Transport
for NSW

New Catherine Field Primary School (SSD 9477)

TAB A – Detailed Comments on State Significant Application SSD 9477

Figure 6: The Catherine Field Public School

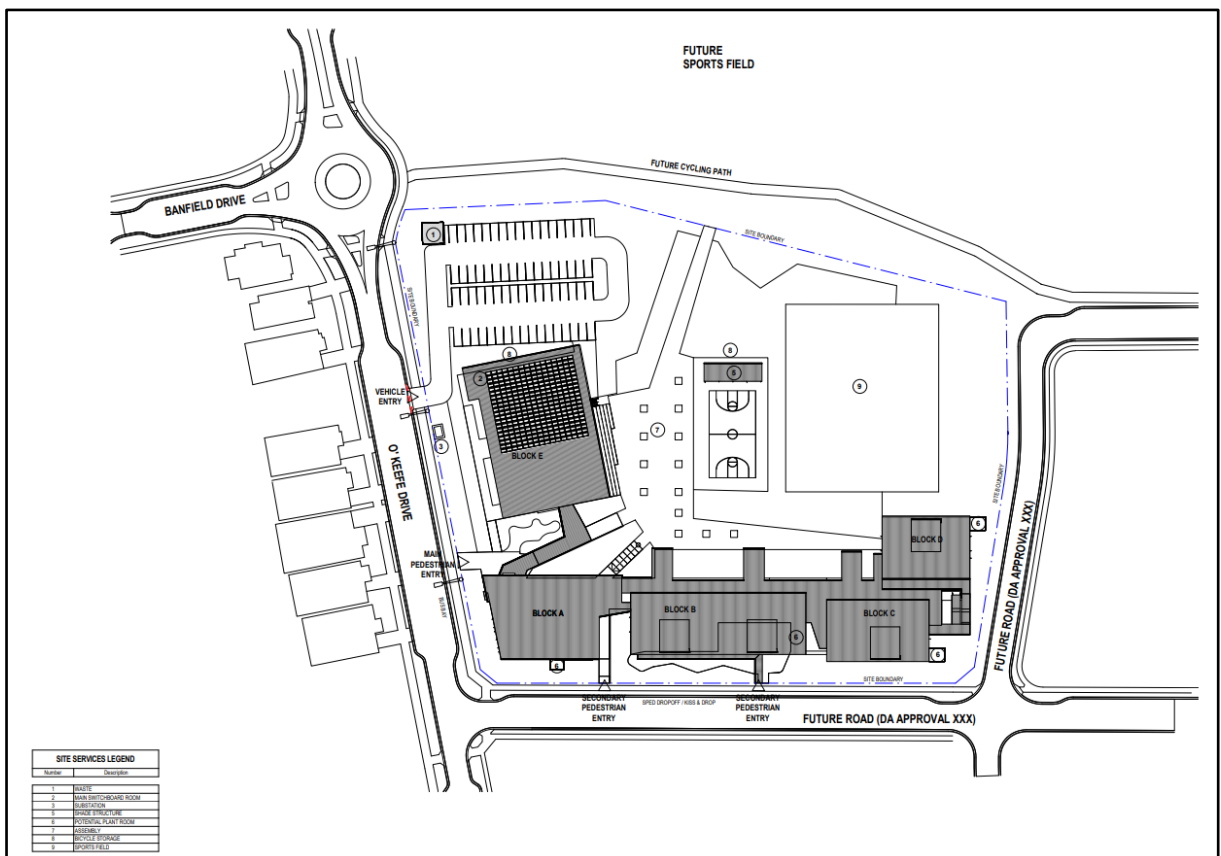
As shown in the Development Control Plan (DCP) and Indicative Layout Plan (ILP) of Catherine Fields (Part) Precinct, O’Keefe Drive is identified as a major collector road within the precinct with proposed regional or district bus routes. The current proposal indicates several facilities, i.e. car park access, DOPU and school bus bays, to be provided at the school frontage on O’Keefe Drive.

Further consideration should be given to the functionality of O’Keefe Drive, in particular:

- School car park access is going through the indented parking lane. Clarification should be provided on how this access will be managed in relation to the parking lane which has already be built on site.
- Impact of DOPU activities during school peak hours occurring on key collector road with (future) regular bus services operating on it.
- Pedestrian connectivity in relation to accessing (future) bus stops on both sides of O’Keefe Drive, having regard to the school traffic and DOPU activities during school peak hours, should be further reviewed in respect to road safety.

Figure 8: 2036 Total Traffic Flows

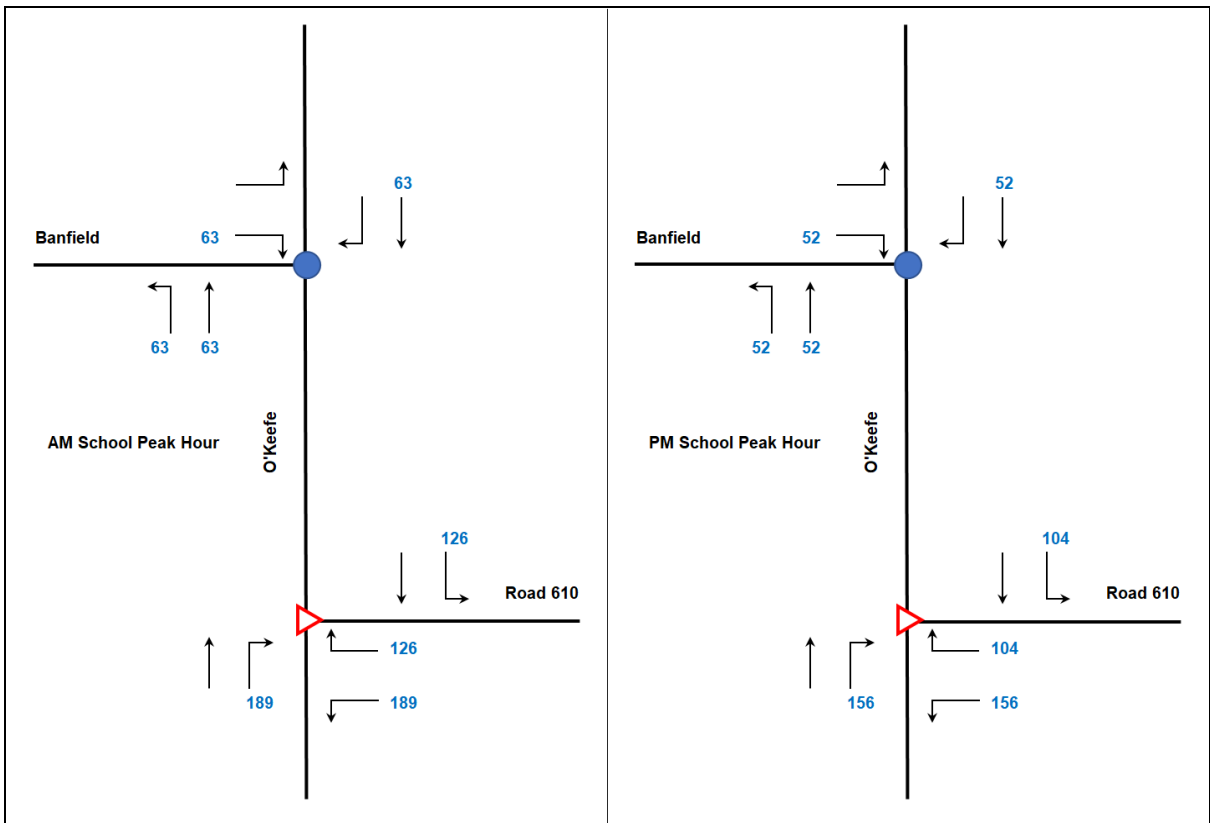
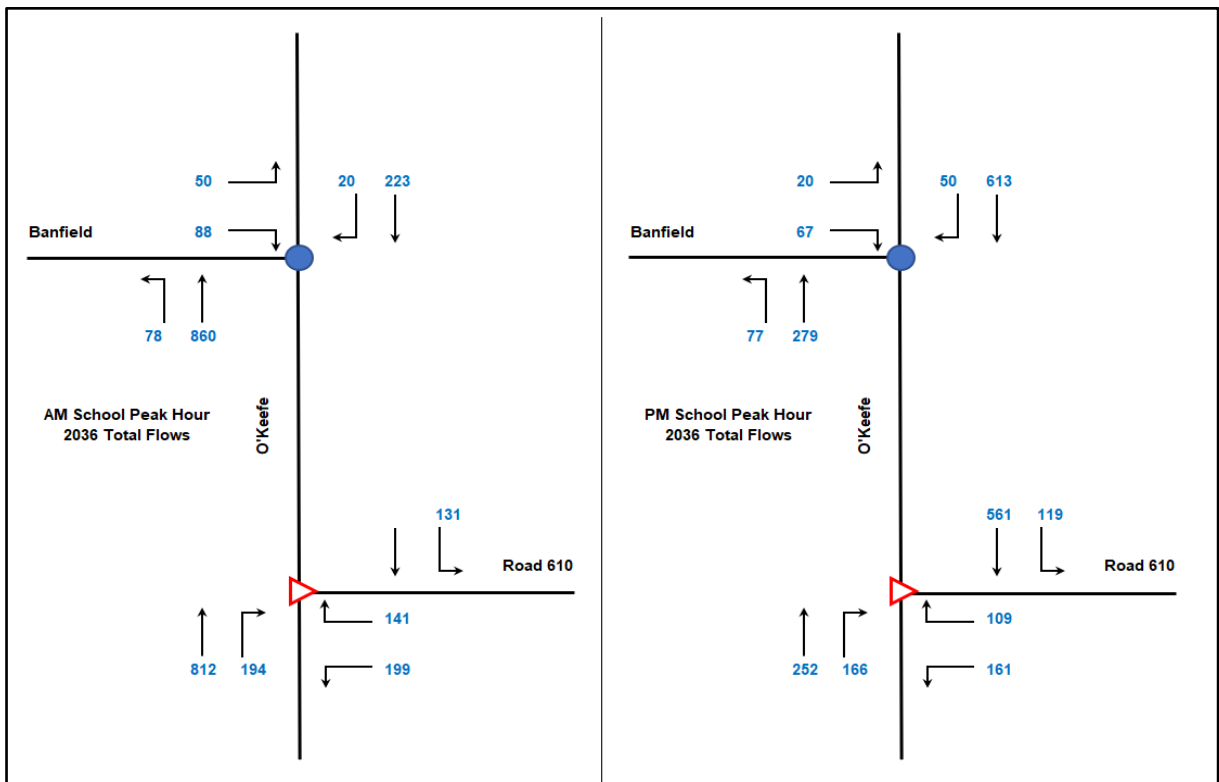
It is noted in Section 6.1.2 of the TIA report that only future intersection performance is shown.

A comparison of pre-development and post-development of intersection performance should be included in the TIA report to determine the impacts of the proposed development on the surrounding road network.

Figure 9: PM School Peak Pick-Up Peak Demand

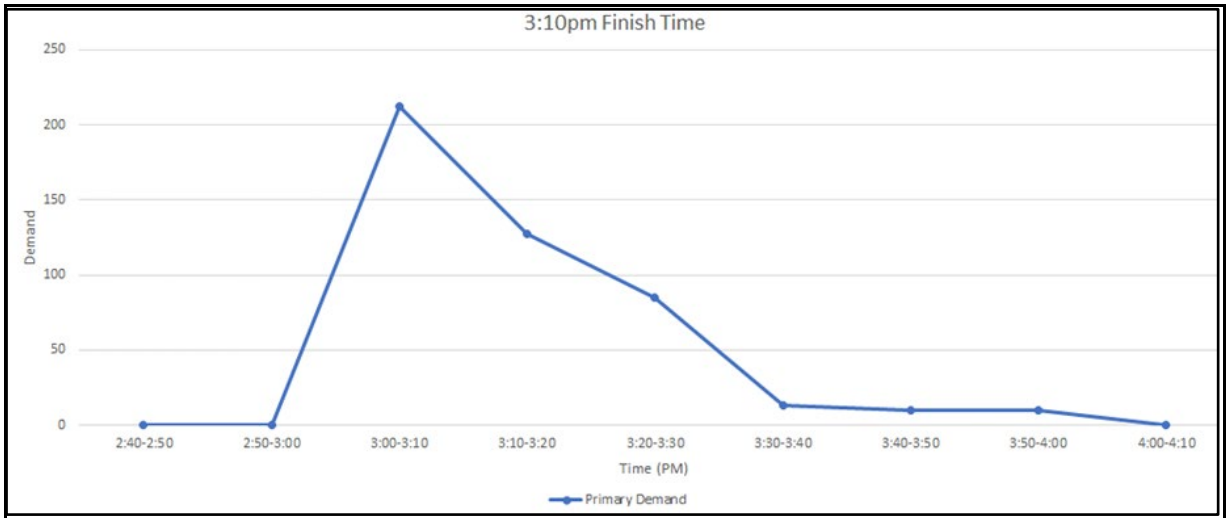
The TIA report suggests that the proposed DOPU zone will be managed and time restricted to maximum 2 minutes. The report also acknowledges that a longer average standing time is required in the PM school peak as parents/carers would normally arrive prior to the end of school to wait for the students. It is evident that the analysis of DOPU movements is based on a 2-minute usage time over a 45 minute period without considering the demand of parents/carers waiting prior to end of school. It is also commonly observed at primary schools that some short-term parking demand would be generated by parents/carers of younger students who would stay till start of school in the AM school peak.

Further analysis should be provided in assessing the drop-off/pick-up demand, including short-term parking demand, around the school site and identify practical measures to alleviate the impact if necessary.
